State of Washington
DEPARTMENT OF FISH AND WILDLIFE

SUBJECT: WDFW COMMENTS ON PF-24-00003 WSDOT WEIGH STATION

Critical Areas Map

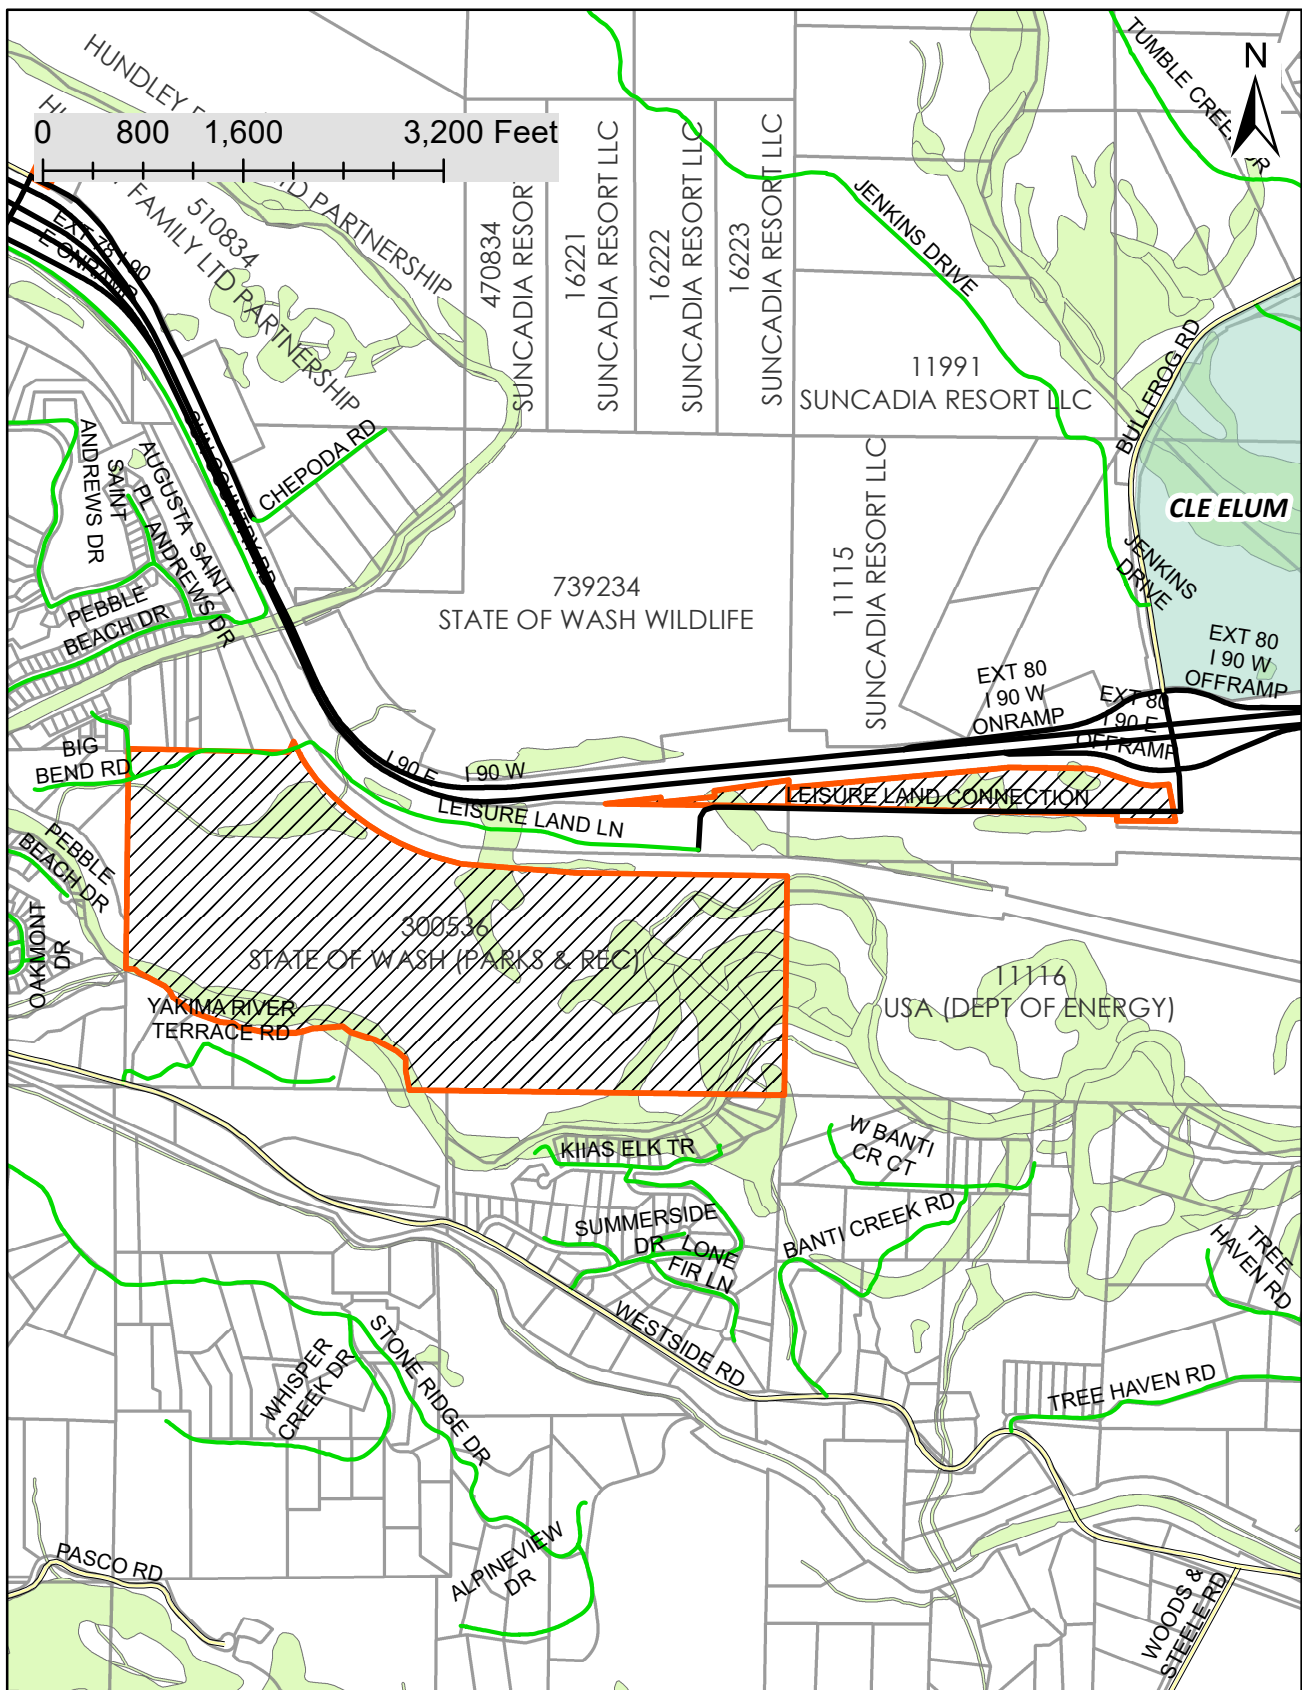
The permanent encroachment into the identified wetland buffers and removal of the forested habitats on site will have an impact to wildlife and habitats in the area and mitigation to compensate for the loss of habitat may be appropriate, after minimization measures have been incorporated.

We recommend limiting the amount of clearing and grading to only the amount needed for the project footprint; existing habitat structures such as shrubs, logs and snags can and do provide immense wildlife benefit even in developed settings. Further, minimizing the impervious surfaces associated with the project to reduce the likelihood of changes to wetland hydrology, and/or additional native plantings around the wetlands will aide in maintaining existing habitat.
